OUT21/7458

**Narrabri Underground Mine Stage 3 Extension Project (SSD-10269)  
Response to Submissions (RTS) and Additional Information**

Mitchell Isaacs  
Chief Knowledge Officer  
**Department of Planning, Industry and Environment: Water**  
11 August 2021

# Detailed advice to DPIE Planning & Assessment regarding the Narrabri Underground Mine Stage 3 Extension Project (SSD-10269) RTS and Additional Information

The existing environmental monitoring locations at the Narrabri Mine is presented on Figure 2-4.

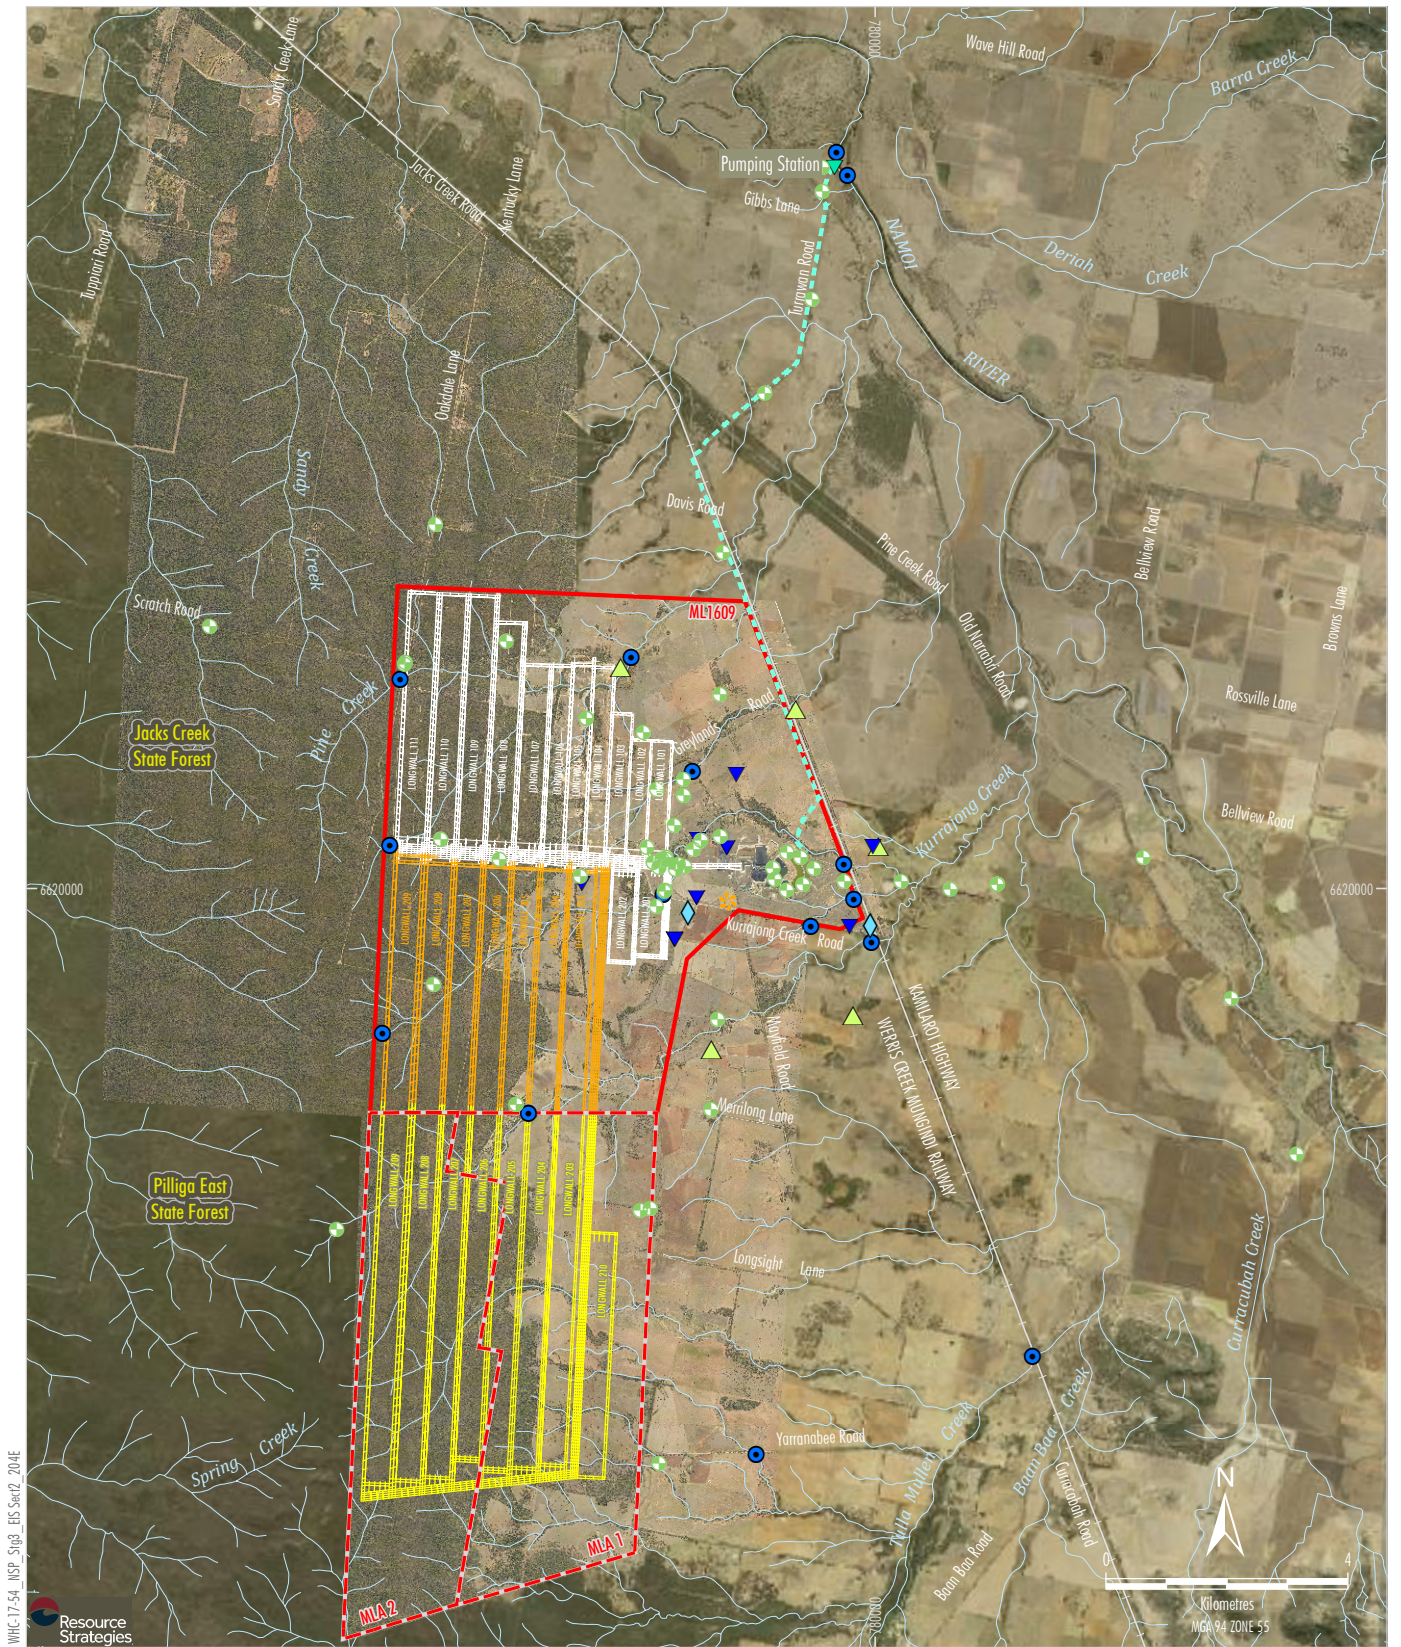
The Submissions Report, and current Subsidence Monitoring Program and Extraction Plan do not present or commit to providing a clear analytical methodology for differentiating pore-pressure changes related to subsidence versus other groundwater stressors (climate, third-party land use) and, consequently, for the early detection of subsidence-related impacts.

Six additional groundwater monitoring sites have been proposed for installation along the boundary or to the south of the lease following project approval. Each of these sites is to include a standpipe in alluvium, a standpipe in the immediately underlying bedrock, and nested vibrating wire piezometers in the consolidated units. Upon the field verification of groundwater

The proposed two new southern monitoring sites and one eastern site satisfy the recommendation to enable the early detection of impacts on third party bores and the southern high-priority Groundwater Dependent Ecosystem (GDE) areas and would assist in reducing the groundwater model's predictive uncertainty for those areas.

We recommend that additional site-representative groundwater monitoring infrastructure should be installed for several areas remotely mapped as having high-priority groundwater-dependent vegetation and where drawdown is predicted to exceed the Aquifer Interference Policy 2012 level 1 minimal-impact threshold, including:

- A tributary of Tulla Mullen Creek to the south of the mine, and 2 km south of the proposed new monitoring site number 6 (Submissions Report Fig. 8), where predicted to have a broad area of maximum drawdown exceeding 5 m.
- Areas of red gum and river red gum along Tulla Mullen Creek to the southeast of the mine; the drawdown is predicted to not exceed 5 m, however, that depth (taken from the IESC submission) is not a legislated threshold.
- Areas to the northeast of the mine mapped as shallow wetland sedgeland, box grassy woodland, ironbark, or river red gum. The shallow nature of the sedgeland renders it vulnerable. These areas are near or adjacent to other broad areas of high-priority GDE for which the Aquifer Interference Policy 2012 drawdown threshold is predicted to not be exceeded but also require impact monitoring to account for uncertainty in the drawdown predictions.

- Detail and clarify the methodology applied at groundwater monitoring sites for the early detection of potential subsidence-related impacts including the analytical methodology used for differentiating pore-pressure changes related to subsidence versus other groundwater stressors (climate, third-party land use).
- Provide a field survey to verify the existence, ecological condition, and ecosystem value of any potential high-priority terrestrial GDE located outside the mining leases that are predicted to be potentially impacted by at least 2 m of groundwater drawdown. Some information has been presented on this however it appears to only cover GDEs within the mine lease area.
- For all field verified GDE sites, install site-representative groundwater monitoring infrastructure for inclusion in the monitoring program and establish appropriate make good provisions.
